# CITY OF ALBUQUERQUE

RE: **X-Factor, 3023 Montclair NE**  
**Grading and Drainage Plan**  
**Engineer's Stamp Date (no date, dwg date 2-26-14)(File: G17D089)**

Based upon the information provided in your submittal received 4-7-14, the above referenced plan is approved for Site Plan for Building Permit and Building Permit based on the following condition:

|                     | GRADING AND DRAINAGE PLAN                                                       | DATE 2-26-14          |

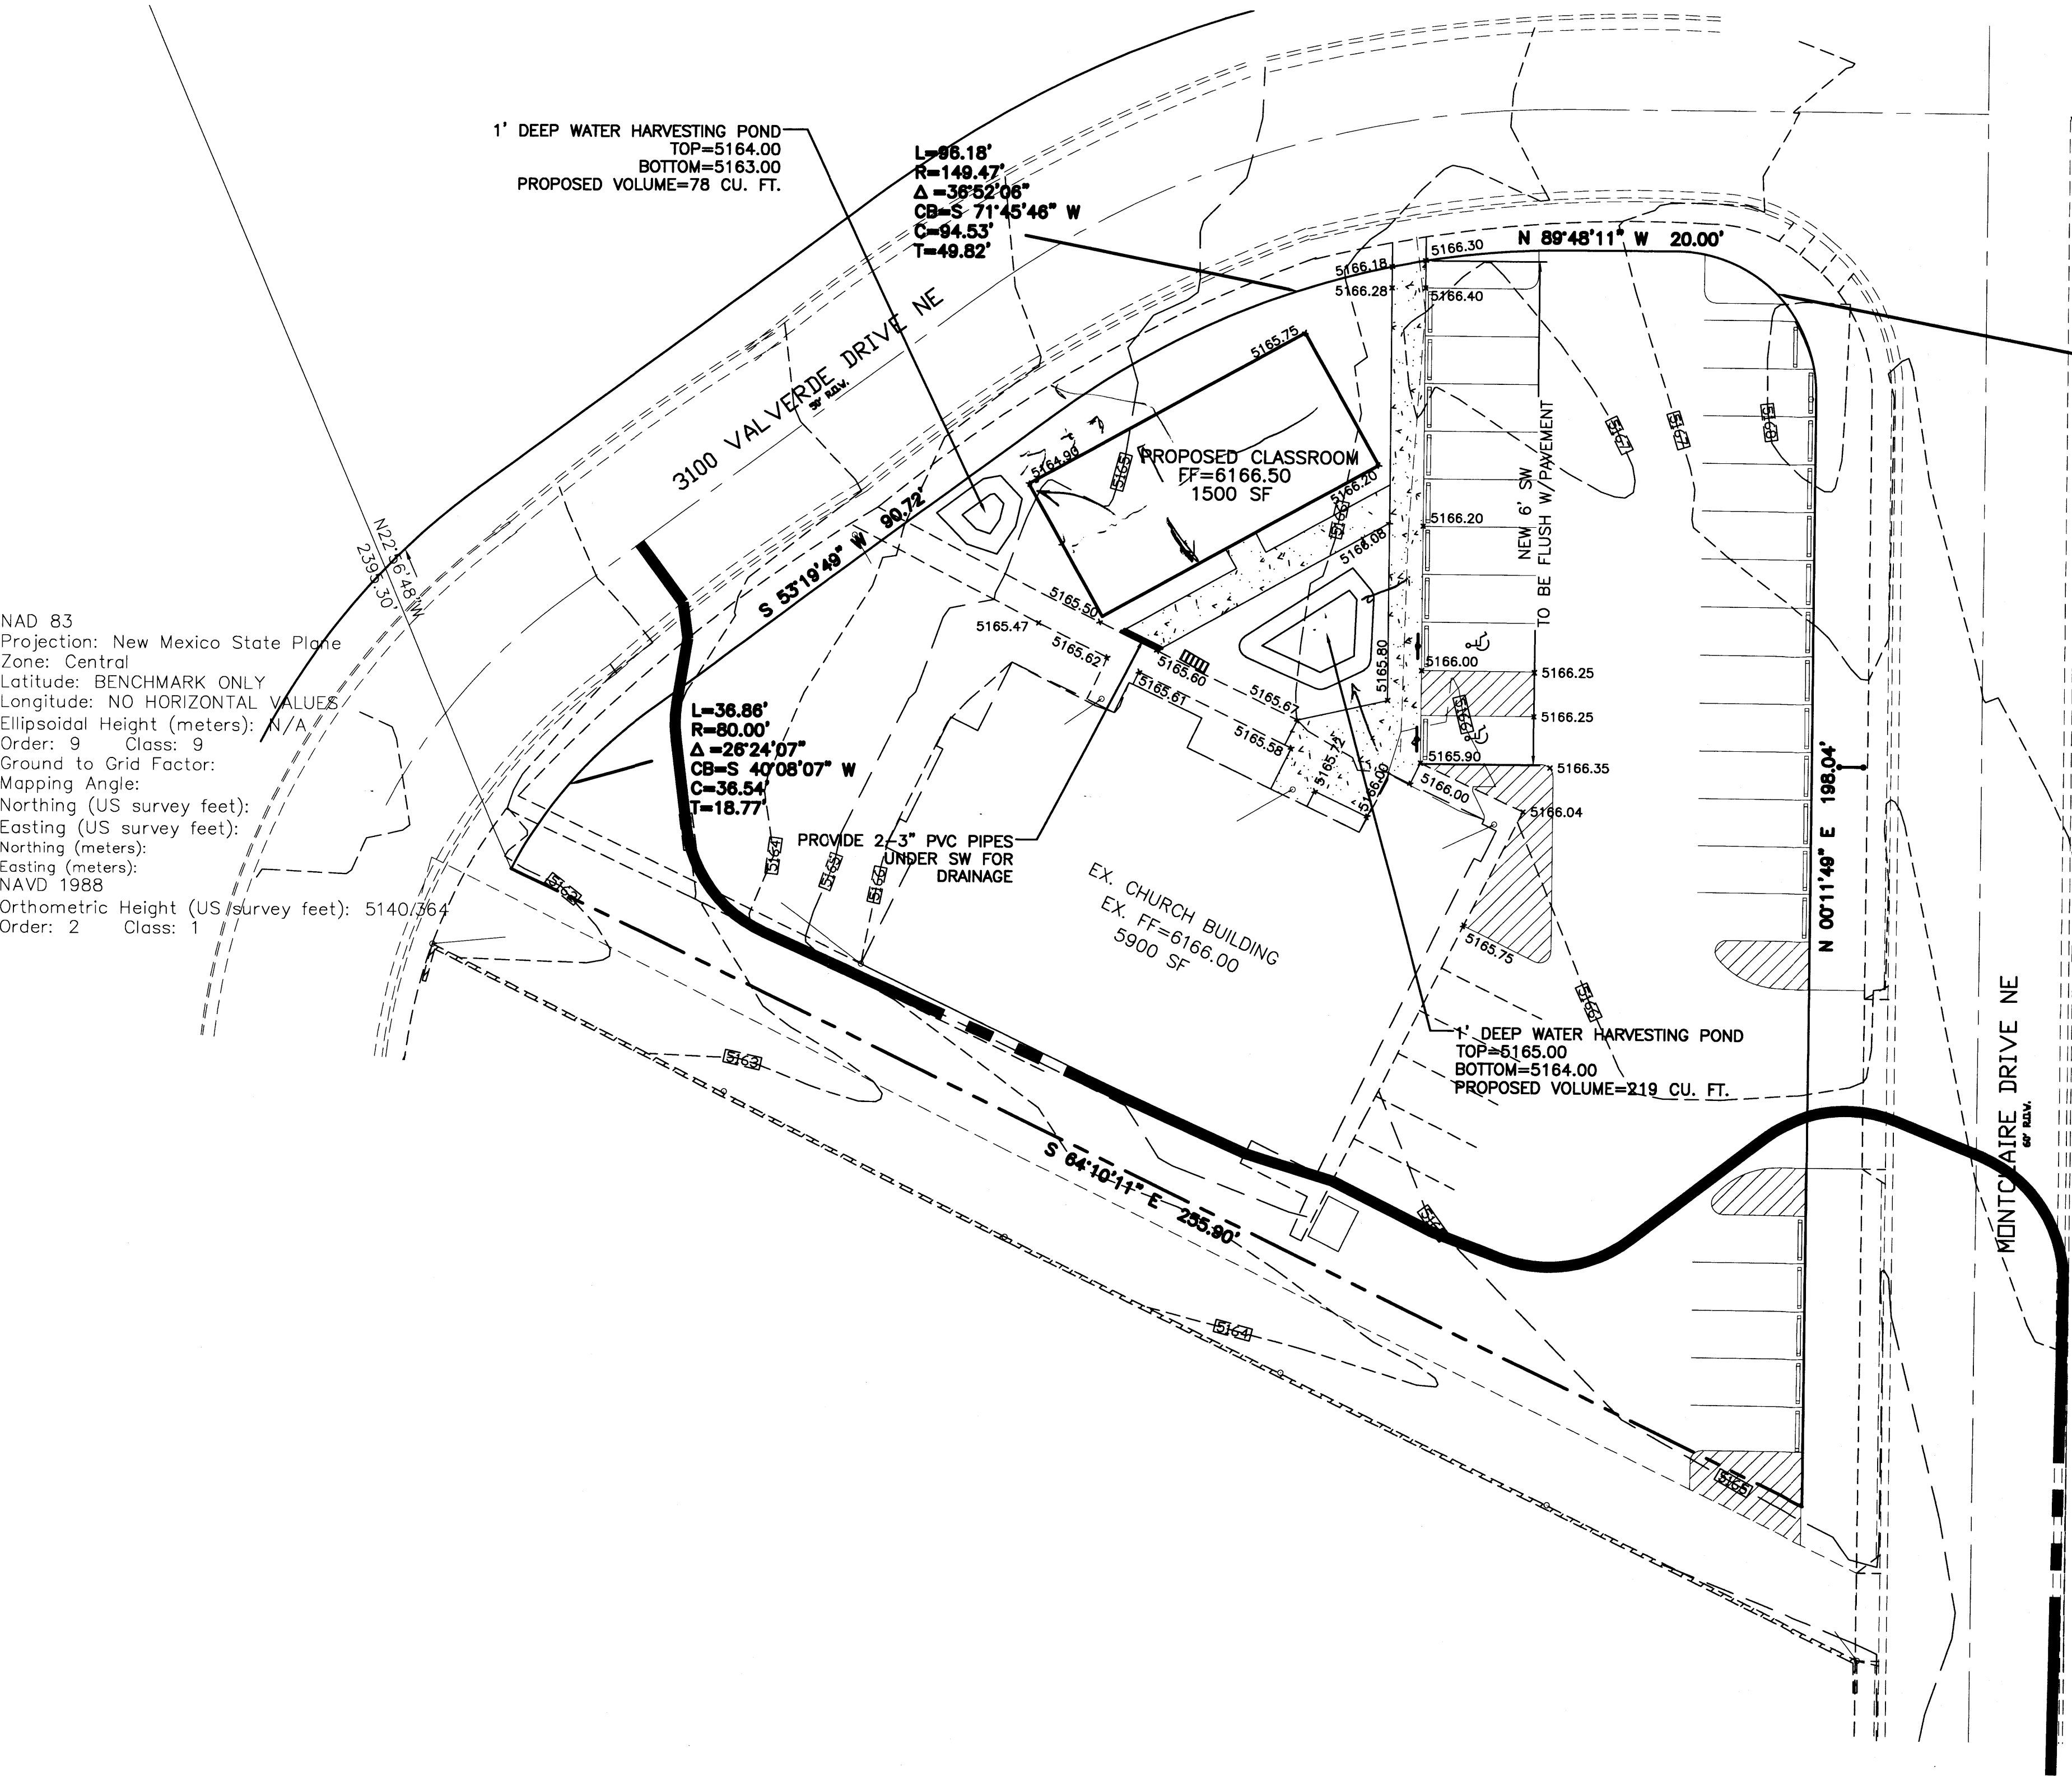
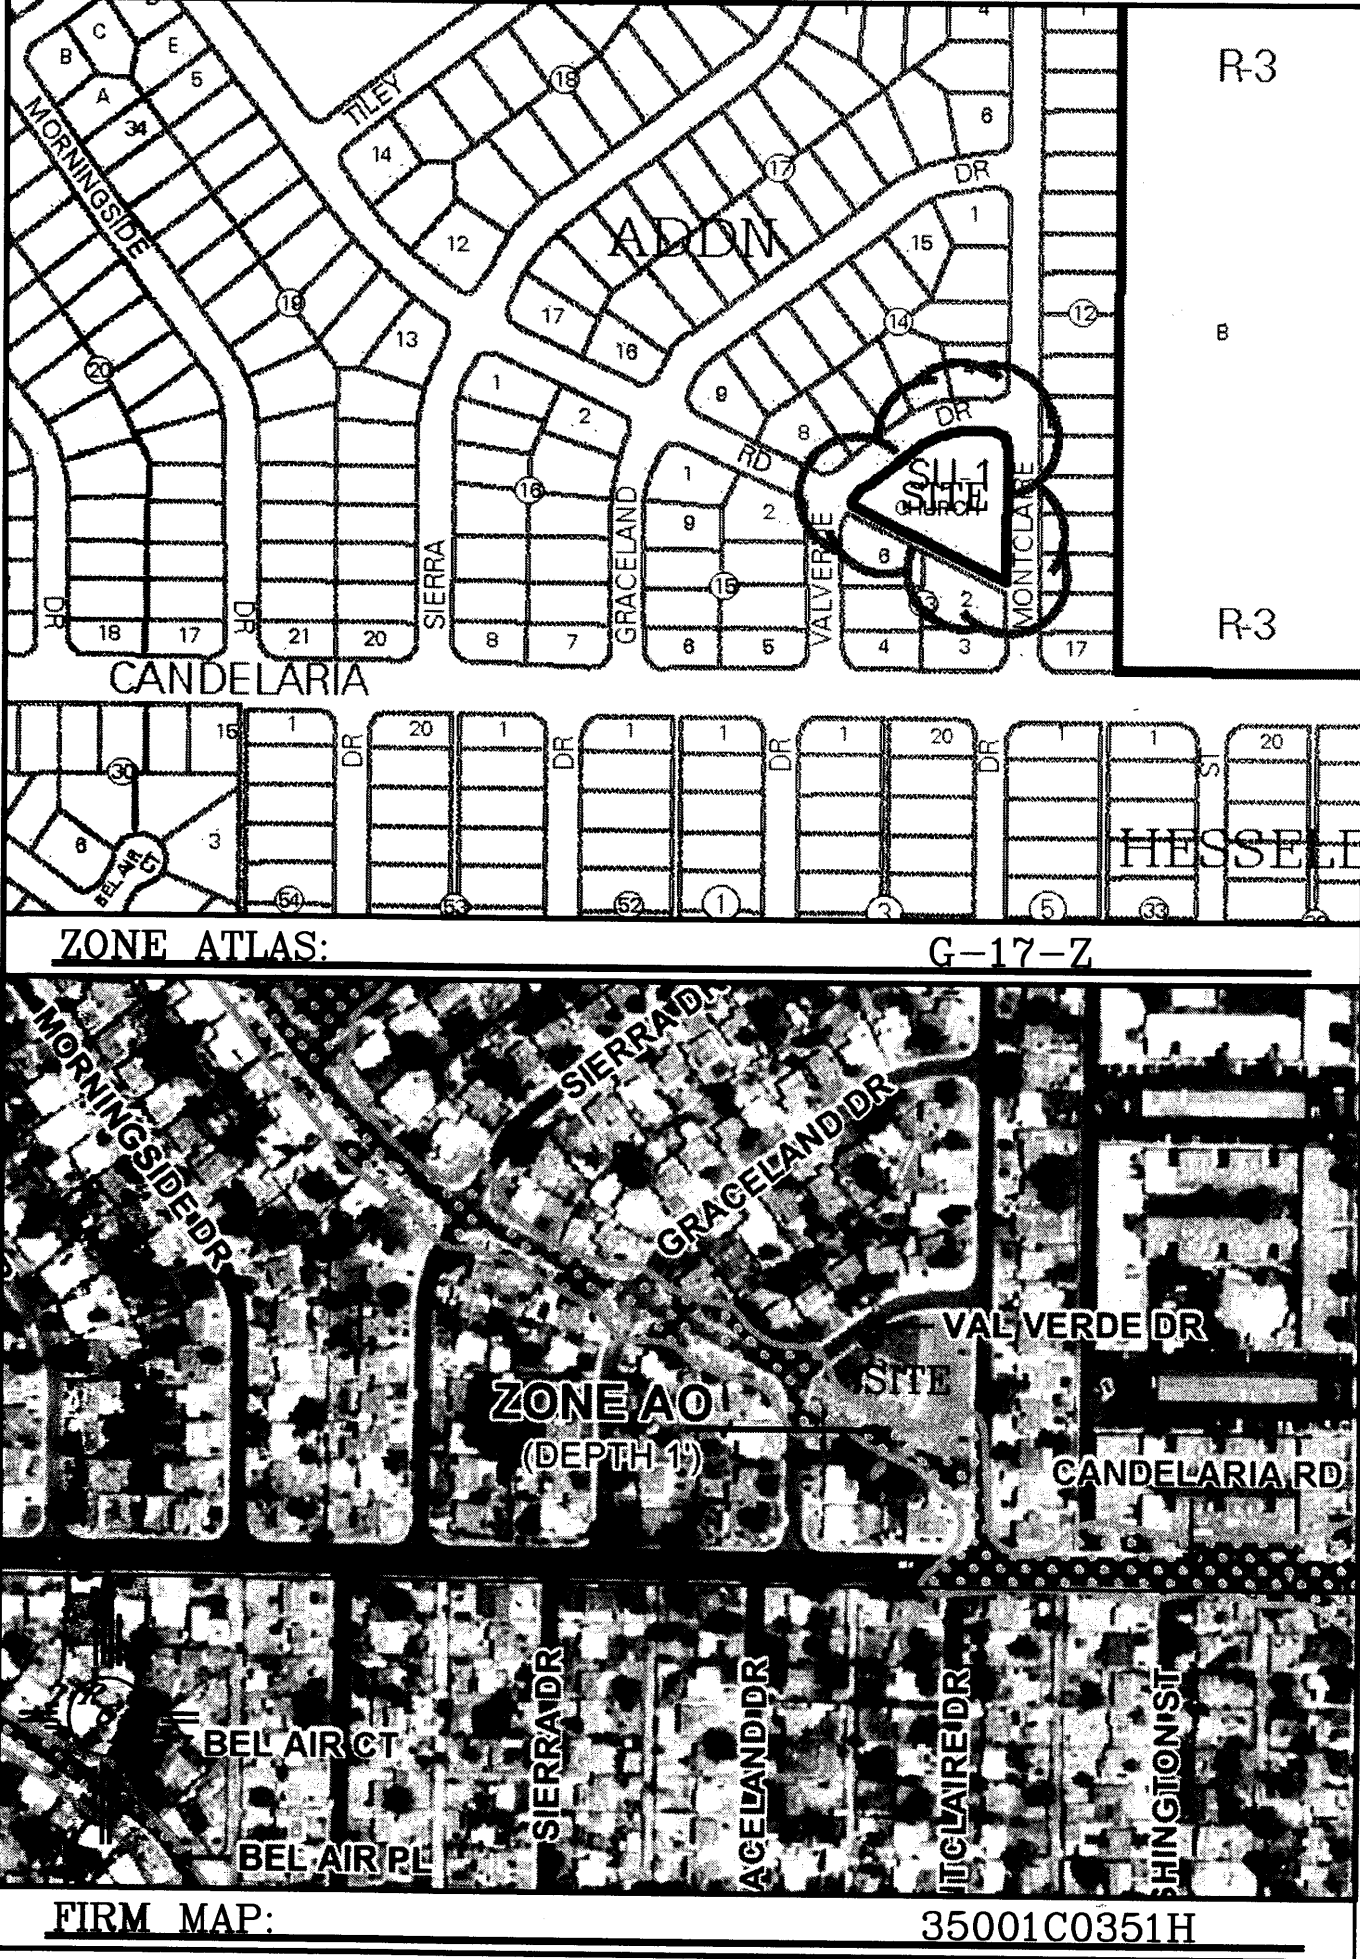
- Prior to Certificate of Occupancy, the As-built Grading and Drainage Plan must show roof and new sidewalks drain into ponds.
